KITTITAS COUNTY

MEMORANDUM

TO: All Staff
FROM: Public Works Plan Review Team
DATE: May 31, 2022
SUBJECT: LPF-22-0003 Evergreen PUD Parcel:B, Div:3
Also known as Blue Jay Land Co.

WINTERFALL AT ROSLYN RIDGE

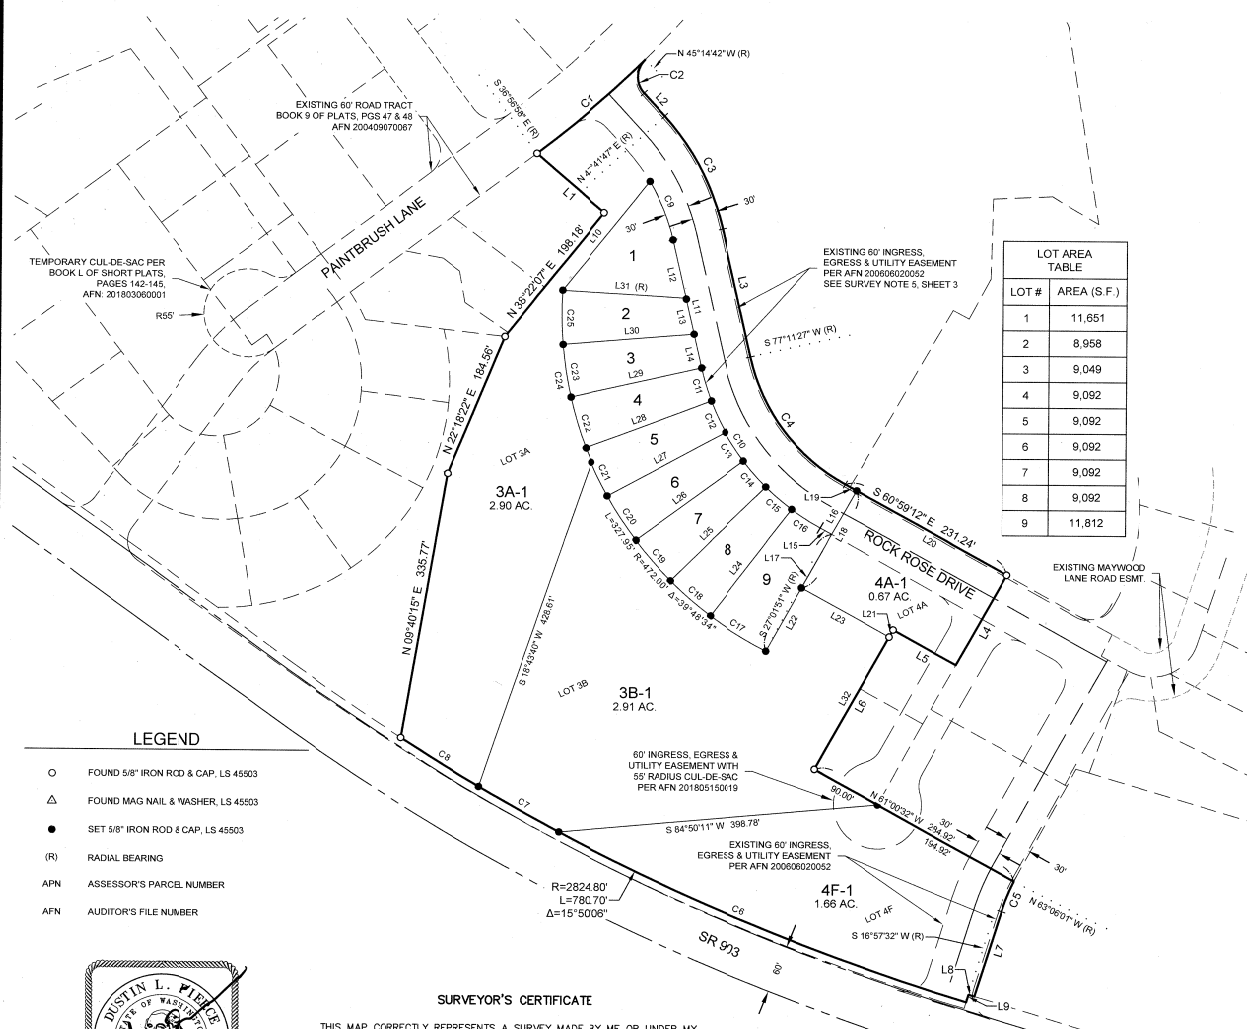
1. The Westernmost point of Parcel 1 may require a detail window to accurately depict curve C28, and the set corner(s) in this area.
2. For all Non-tangent curves, please include radial bearings OR include chord bearing and distances.

1. Please show proof of access for Lots 3A and 3B. During preliminary plat southern lots were accessed by internal roads, but because the roads are not constructed the lots appear to be landlocked.
